**DEVIATION REQUEST
AND DECISION FORM IN
ASSOCIATION WITH A
REQUEST FOR A PUD
MODIFICATION FROM
THE ECM**

Project Name : Urban Landing Preliminary Plan

A deviation from the standards of or in Section **LDC 8.4.4 (E) (2)** and Section 2.2.4.B.7 Fig. 2-17, Table 2-7 and Section 2.3.8 of the Engineering Criteria Manual (ECM) is requested.

FIRE TRUCK SIZE:
8.3' WIDE
43.4' LONG

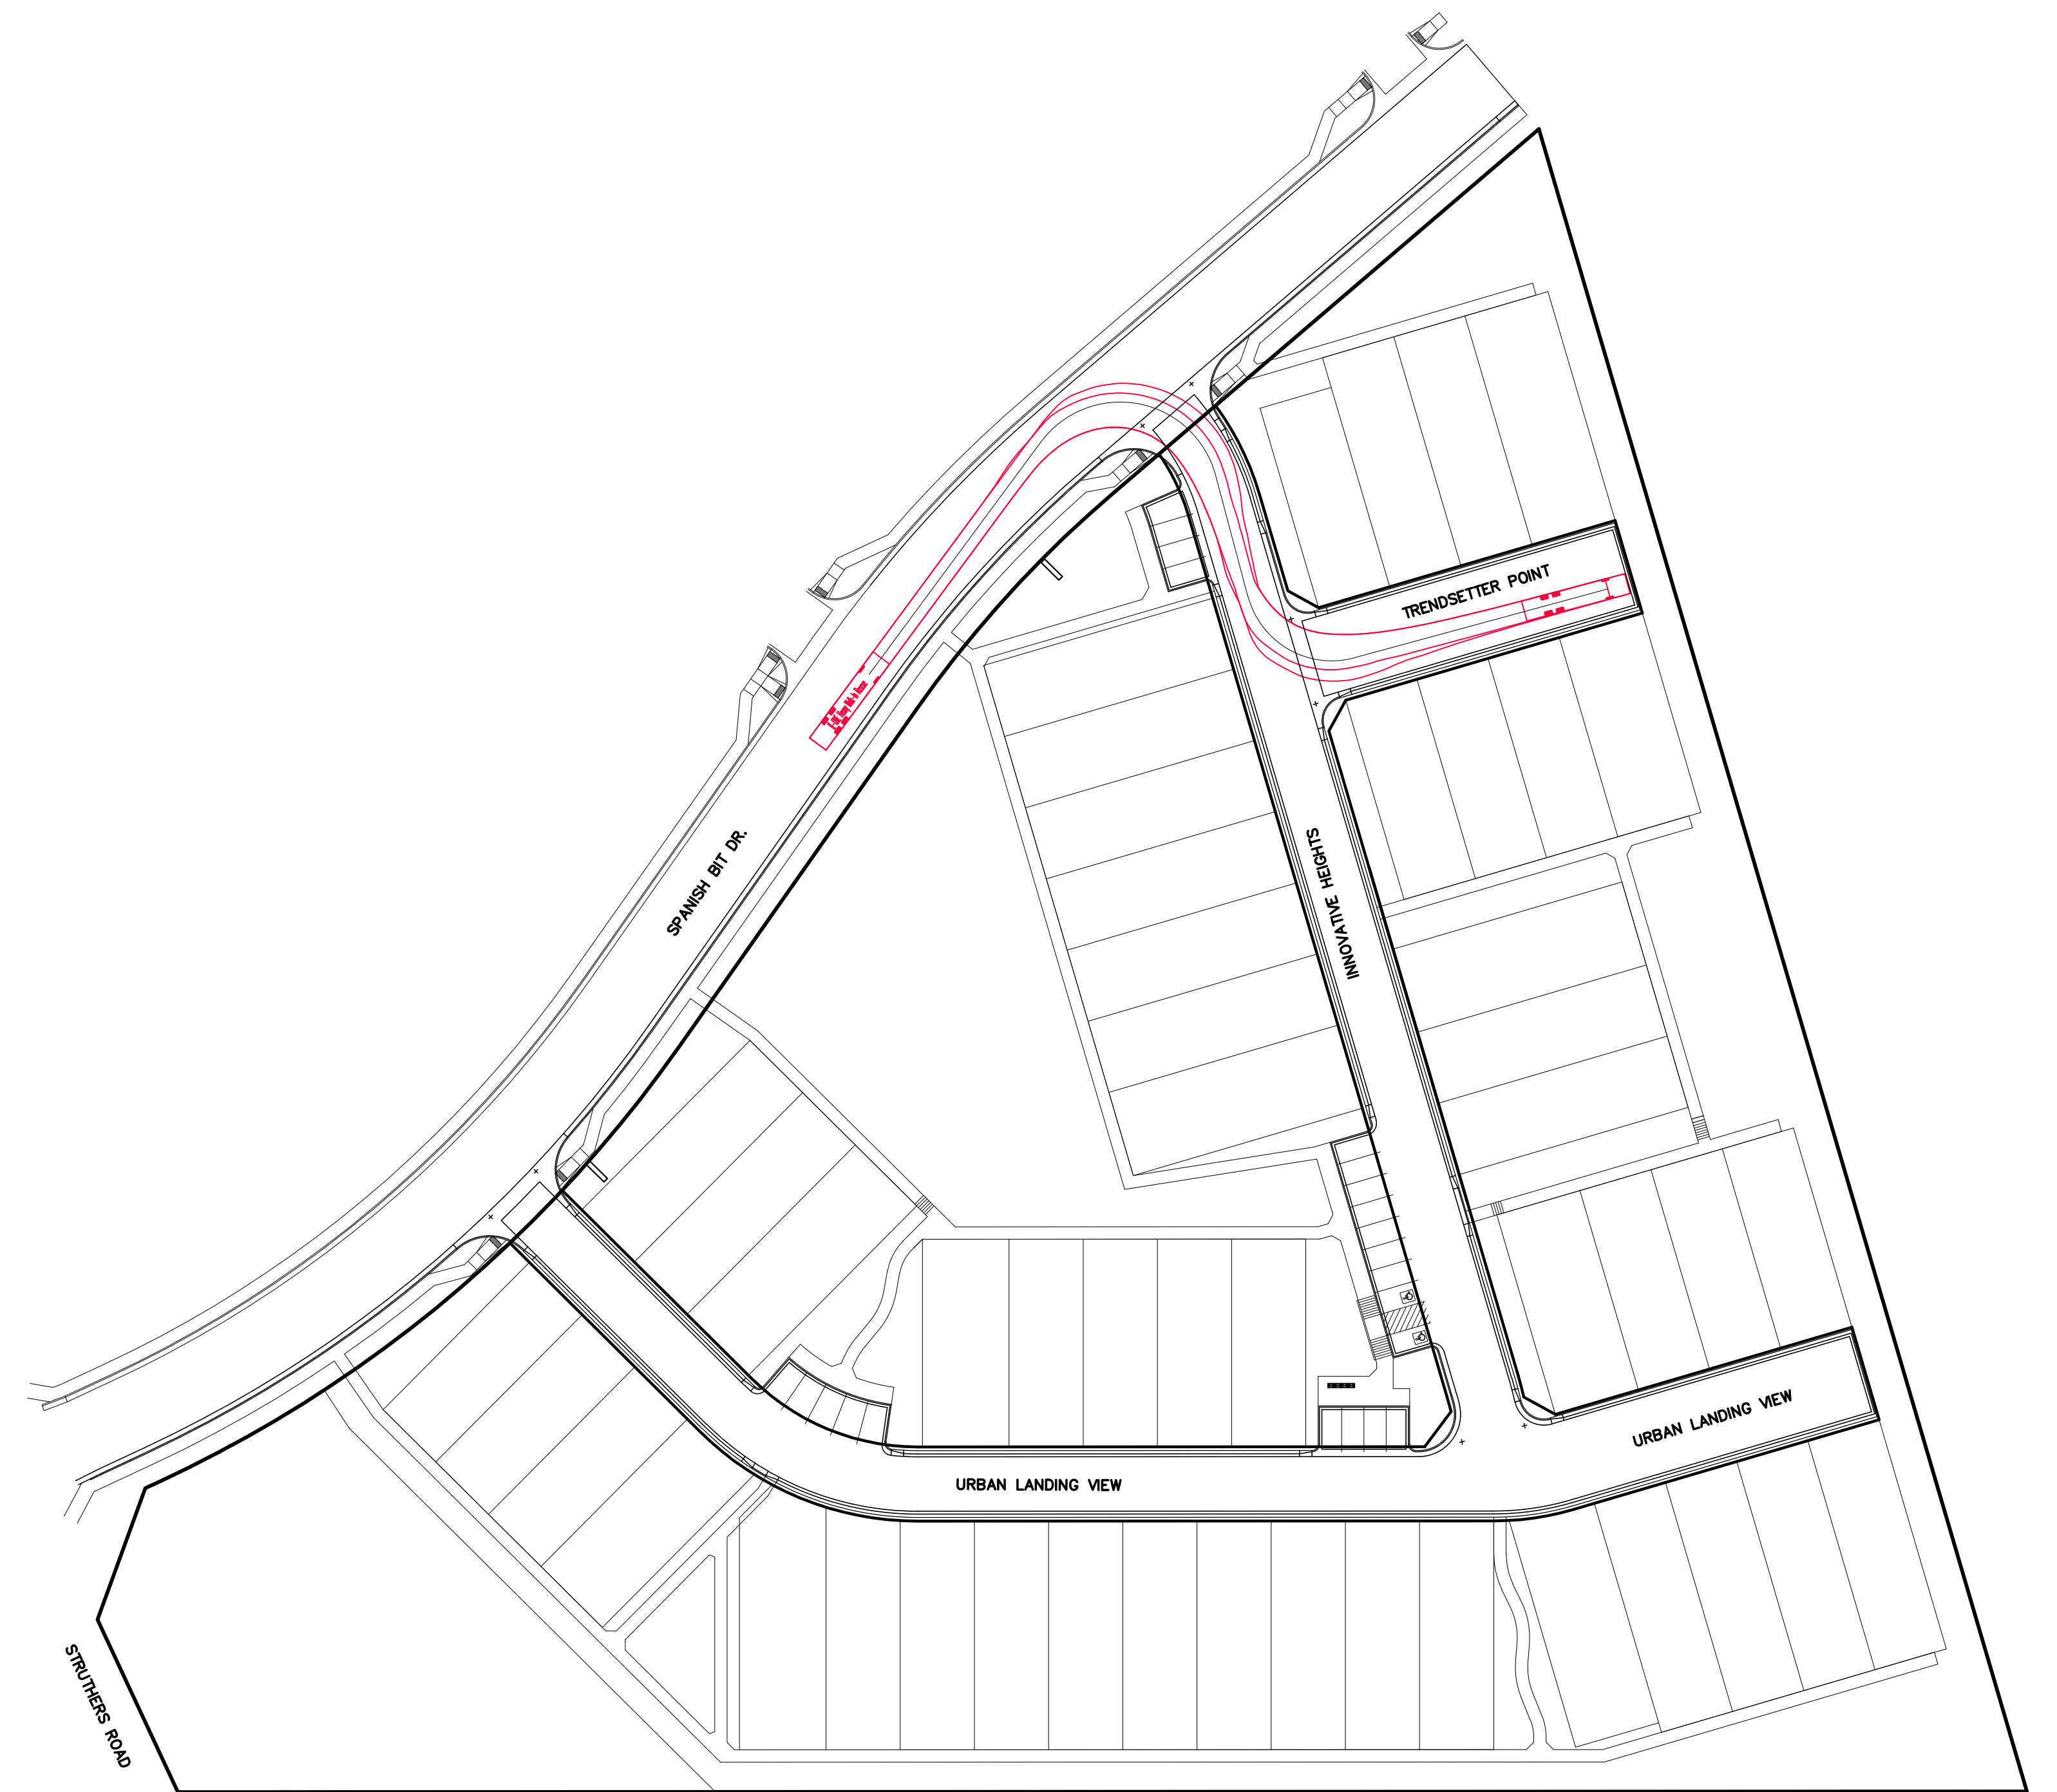
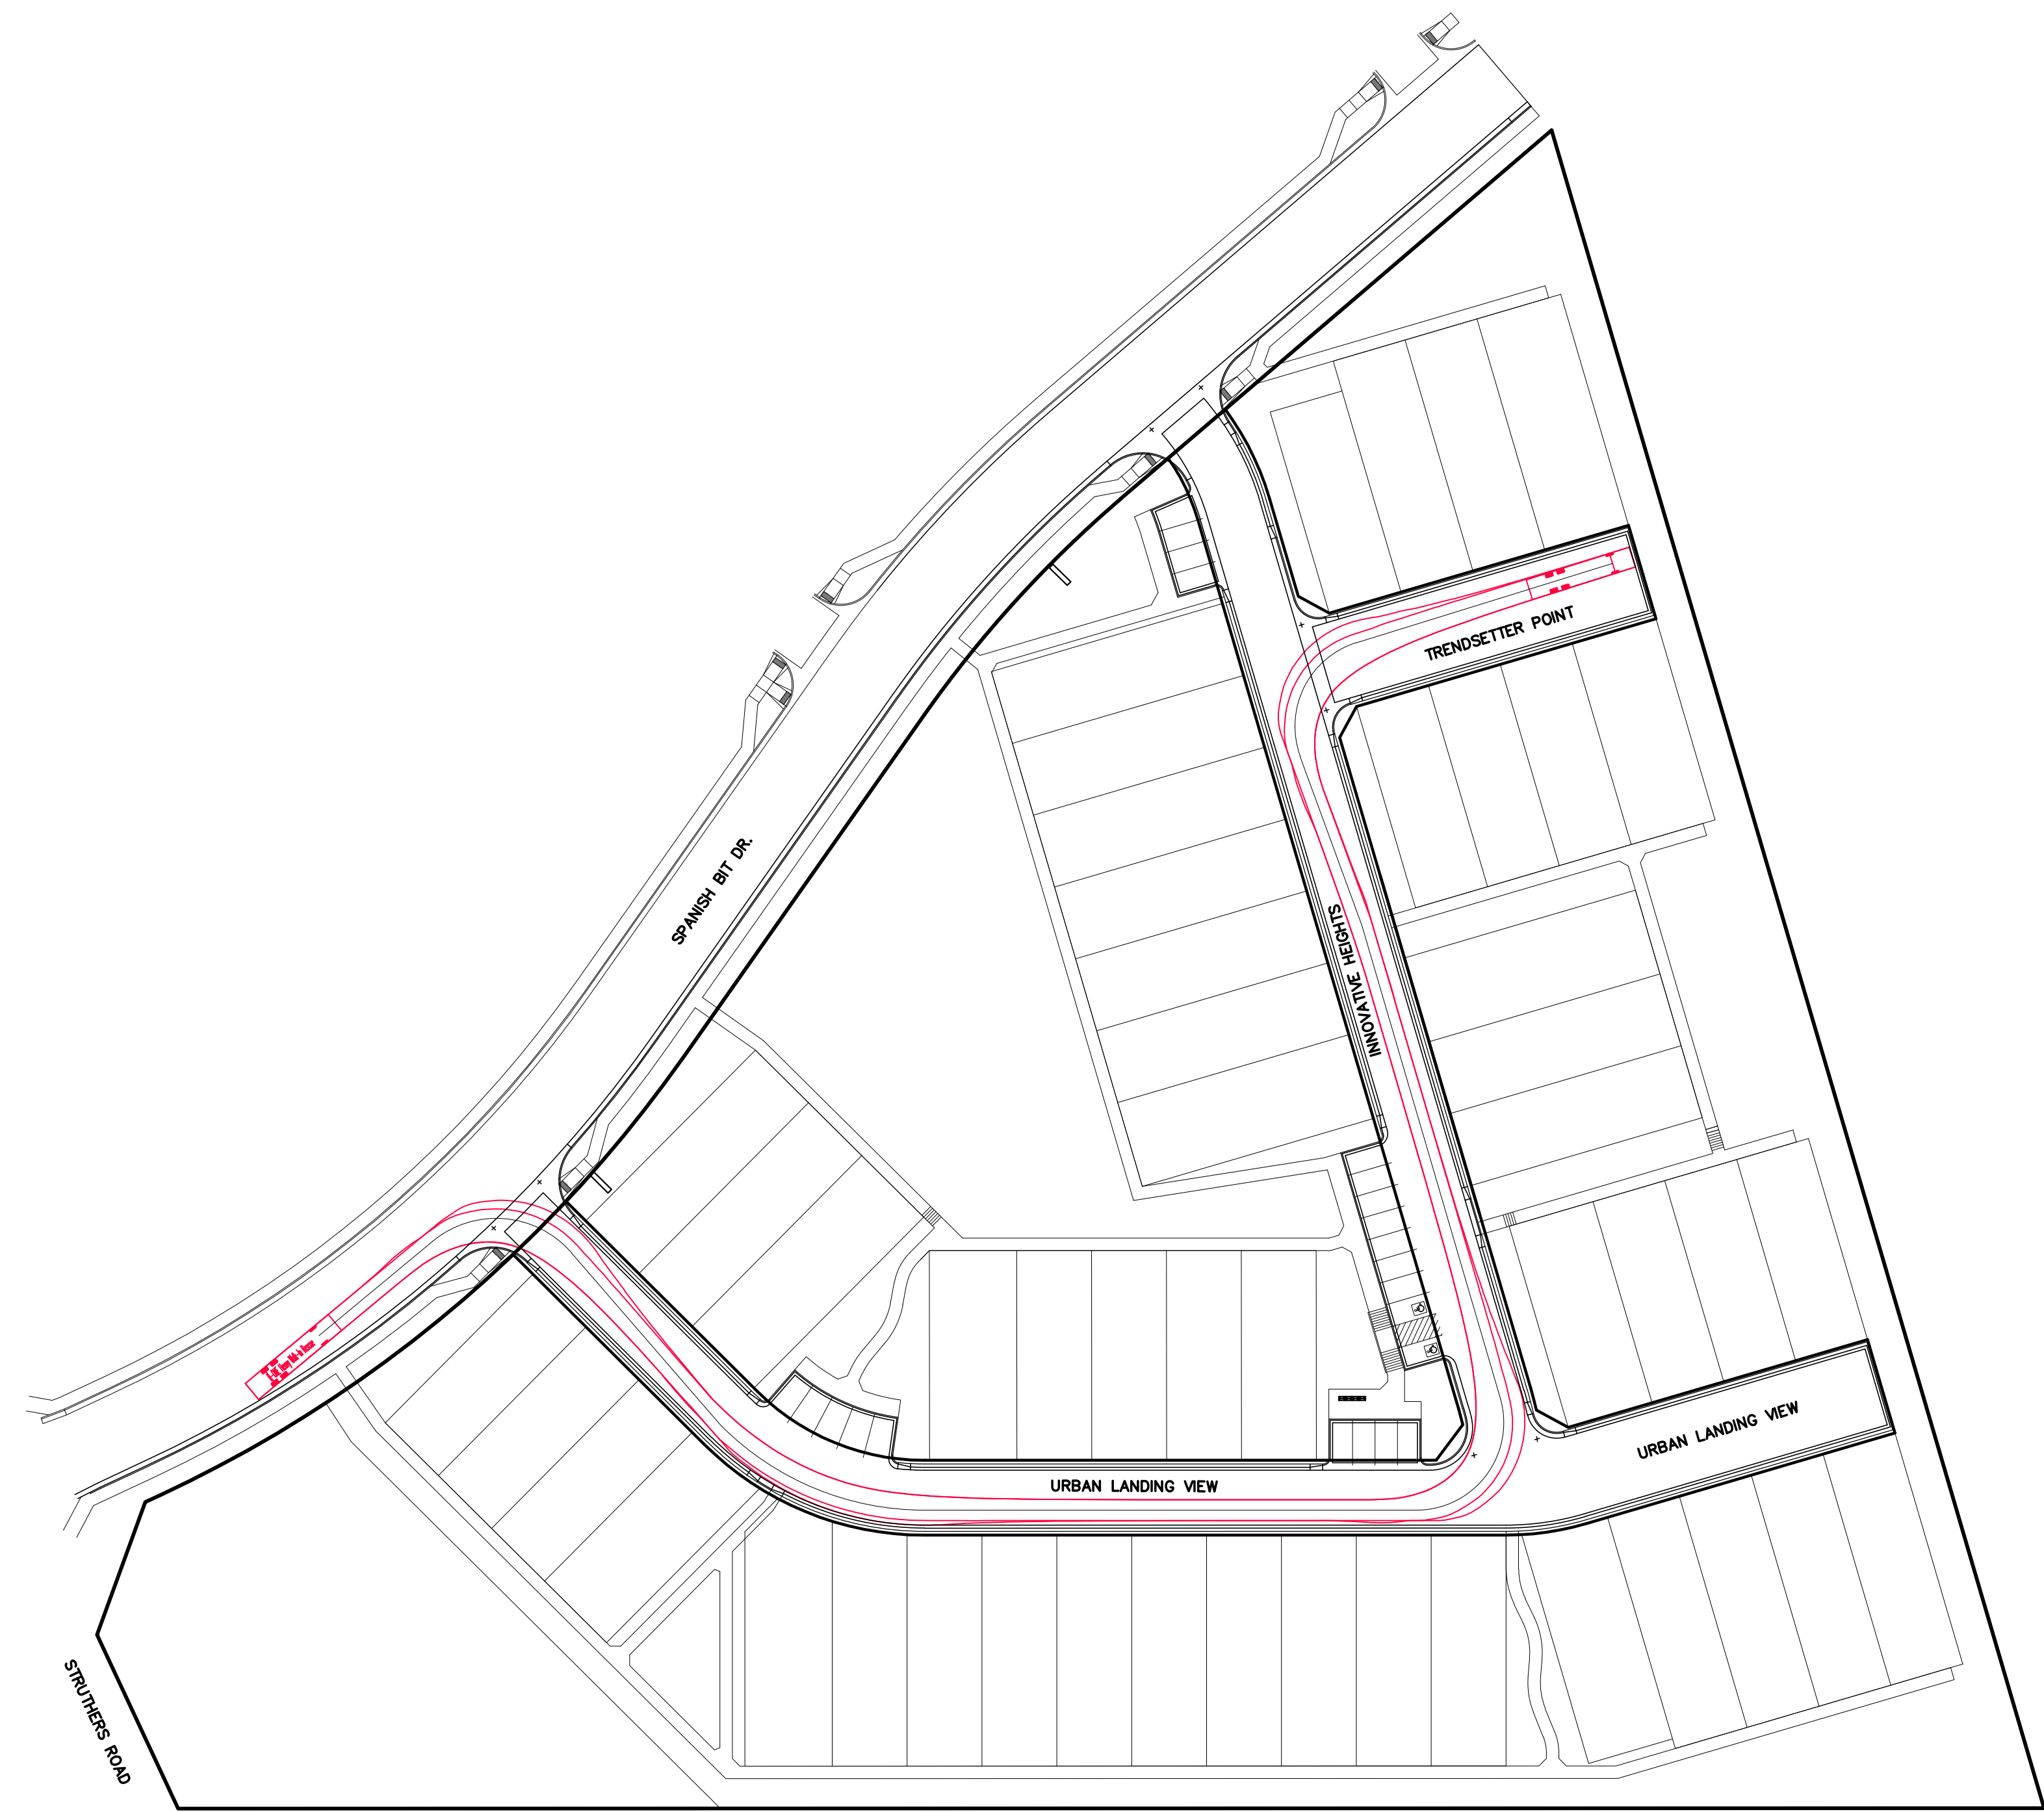
The unique community attributes include a high percentage of open space (30%+) that is the result of the private street use and rear garage access. The front doors of the applicable communities all face green belt open space corridors with pedestrian access from sidewalks within these corridors rather than along the private streets. The reduction in asphalt width has no impact on access or emergency vehicle maneuverability, as discussed with the Monument Fire District and provided fire truck access/turning movement exhibits. Reference attached endorsement e-mail from Monument Fire District.

No. They are short enough that it doesn't trigger a turnaround in the fire code.
